Planning Application Ref: BR/174/21/T

Location: The Maples, 45 Victoria Drive, Bognor Regis, PO21 2TQ

Description of works: Various works to various trees

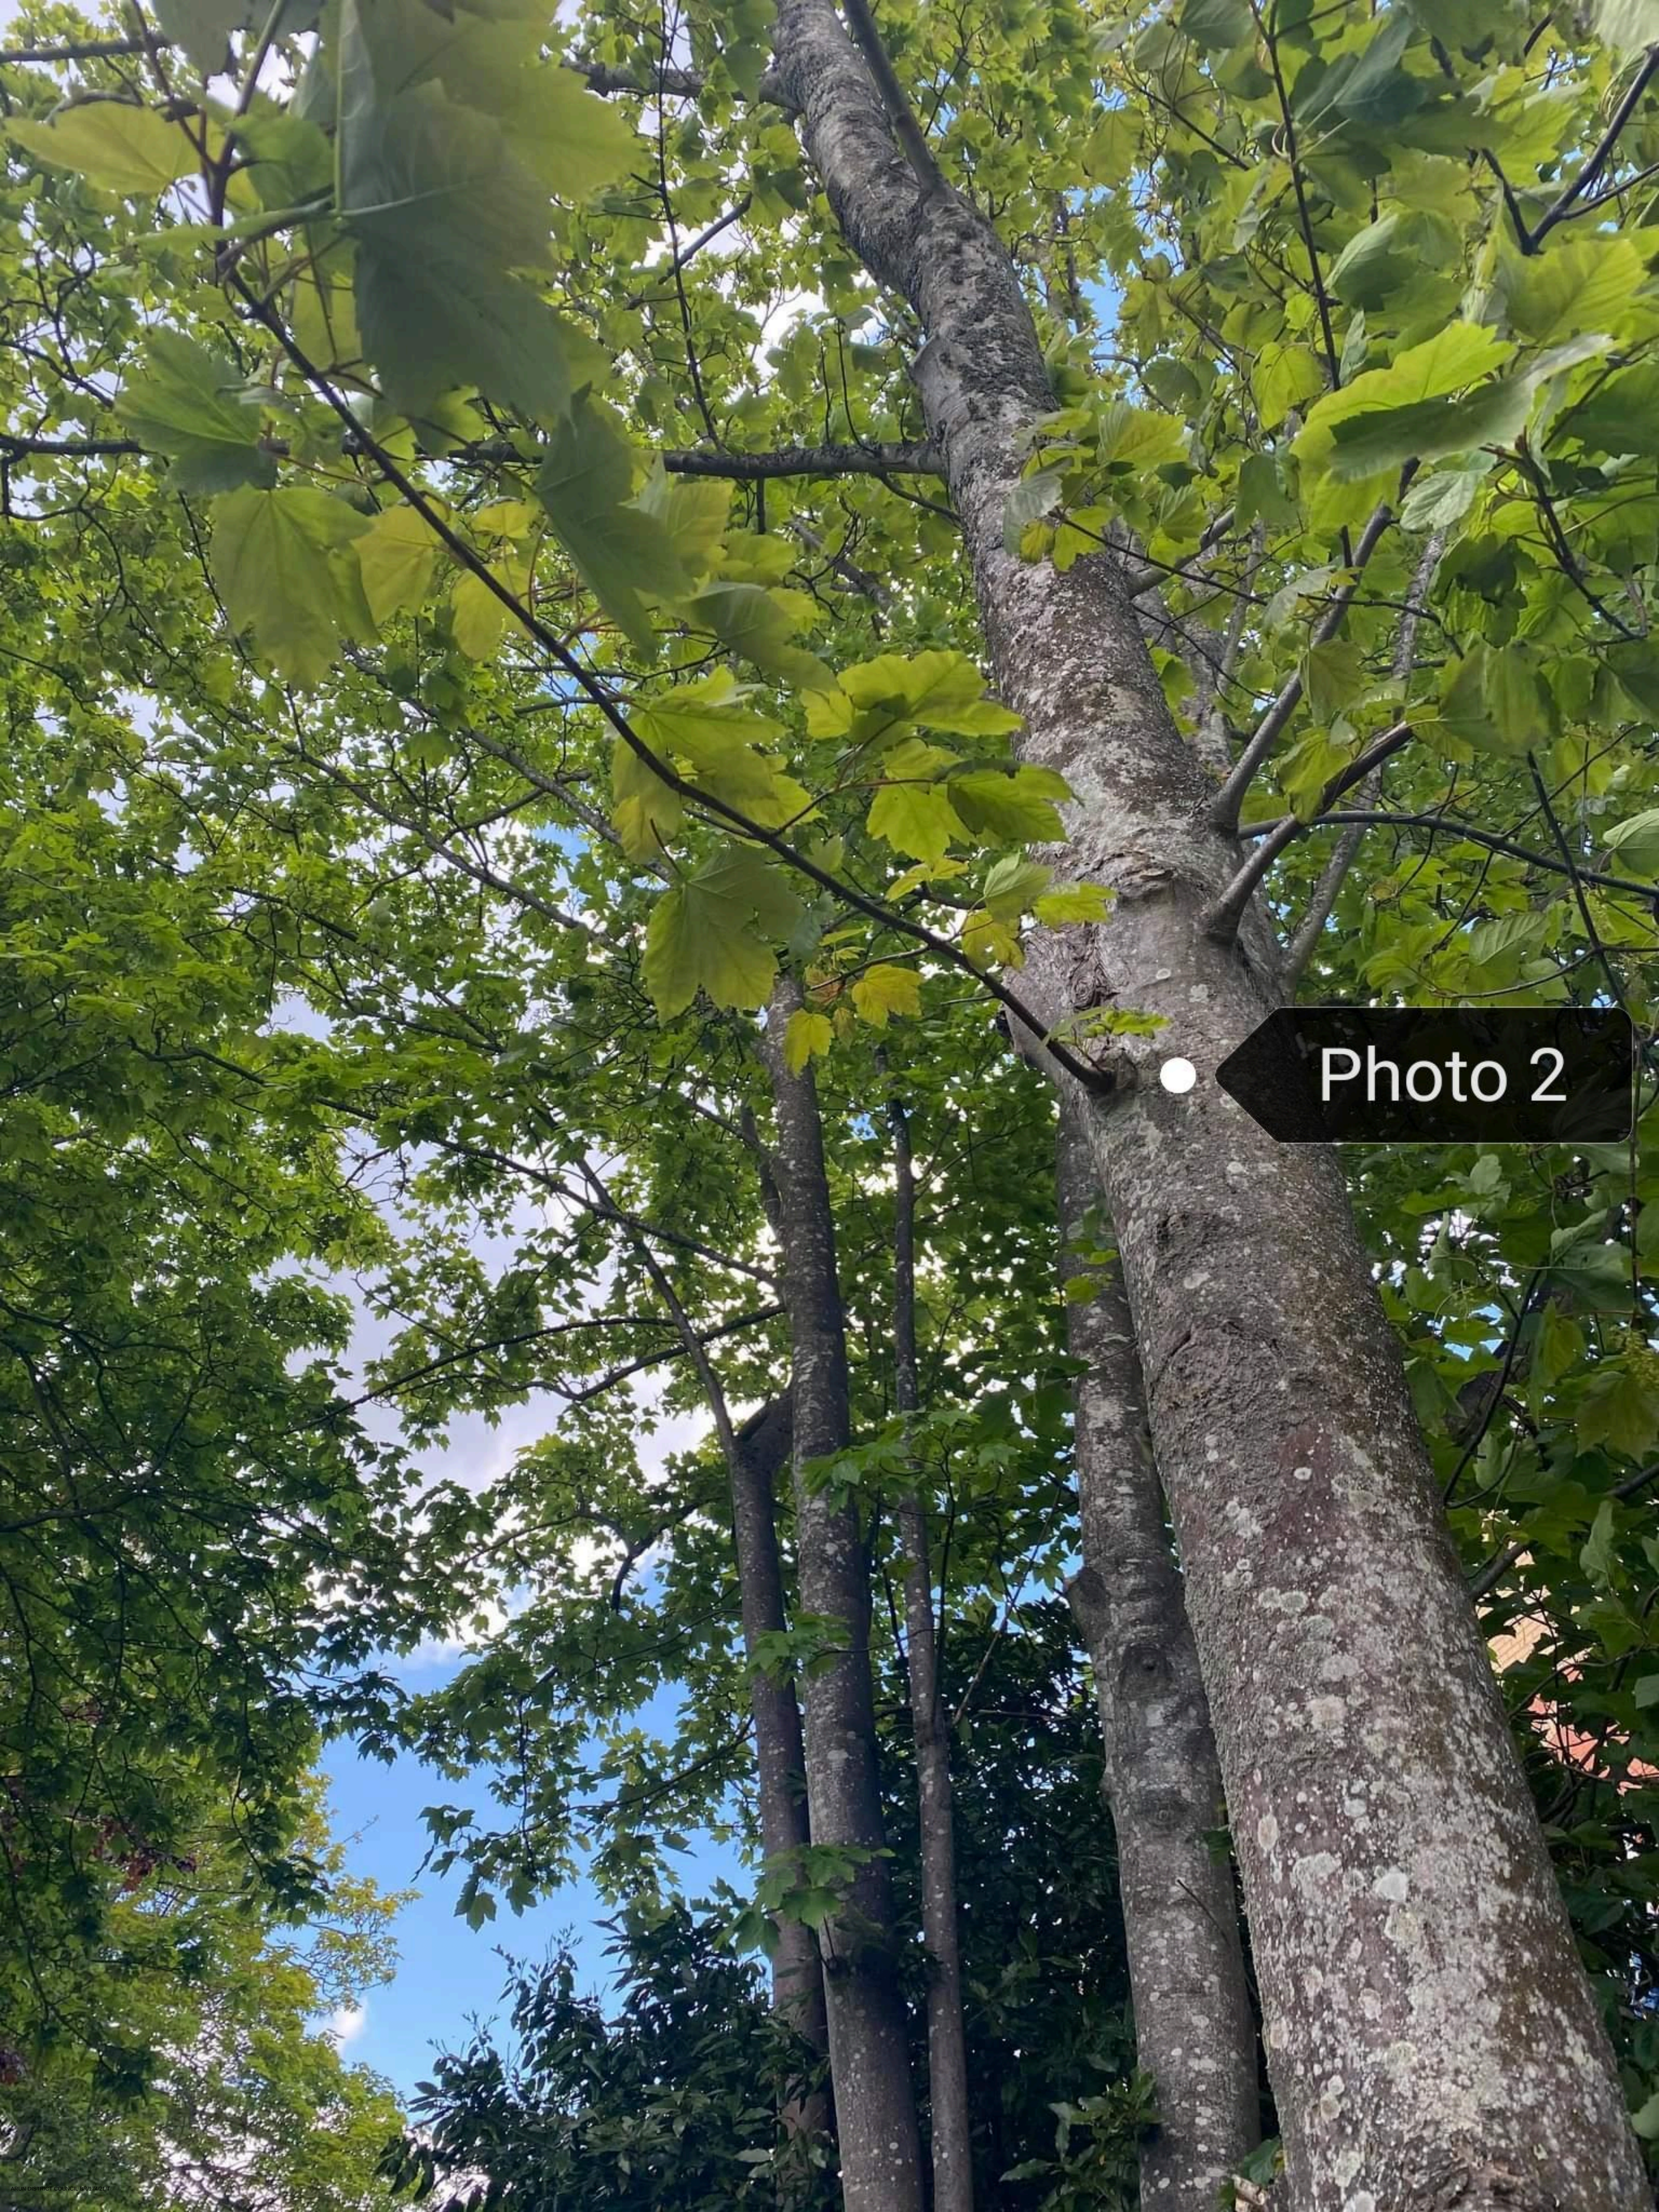
- The site is densely populated with trees along the south boundary, from where the majority of protected trees grow (TPO/3/82 - G4). Those are predominantly early mature sycamore of varying form and overall in good physiological condition. Collectively they present largely unmodified and attractive upper crown profiles, adding maturity to the surroundings. Whilst seasonal nuisance and general influence over residential property is accepted, high-level canopy brings important benefits and visual amenity to the area.

- The agent proposes replacement of two (TPO) trees identified for removal, items 0241 & 0242. That is justified and while I welcome the intent, it may be difficult to ensure the establishment of 'like for like' replacements beneath such dense canopy (perhaps there are locations elsewhere on the site which are more suitable?). Furthermore, their loss will not be detrimental to public amenity and so I would not insist on their replacement.

- I support *crown reduction* pruning, as described, for item 0245, but do not consider it appropriate for: 0252, 0255, 0257 & 0258 at this time.

- The majority of work proposed is justified on arboricultural grounds and would not incur loss of public visual amenity.
- There are four established sycamore of apparent good form, for which justification has not been provided for proposed crown reduction pruning at this time. Such work would diminish their place in the landscape.

- As it stands, I recommend **REFUSAL** for this application.
- **I would like the applicant to be invited to agree to a revised proposal for lesser works** (by removing crown reduction pruning to items: 0252, 0255, 0257, 0258) as part of the current application so as not to incur further delay.
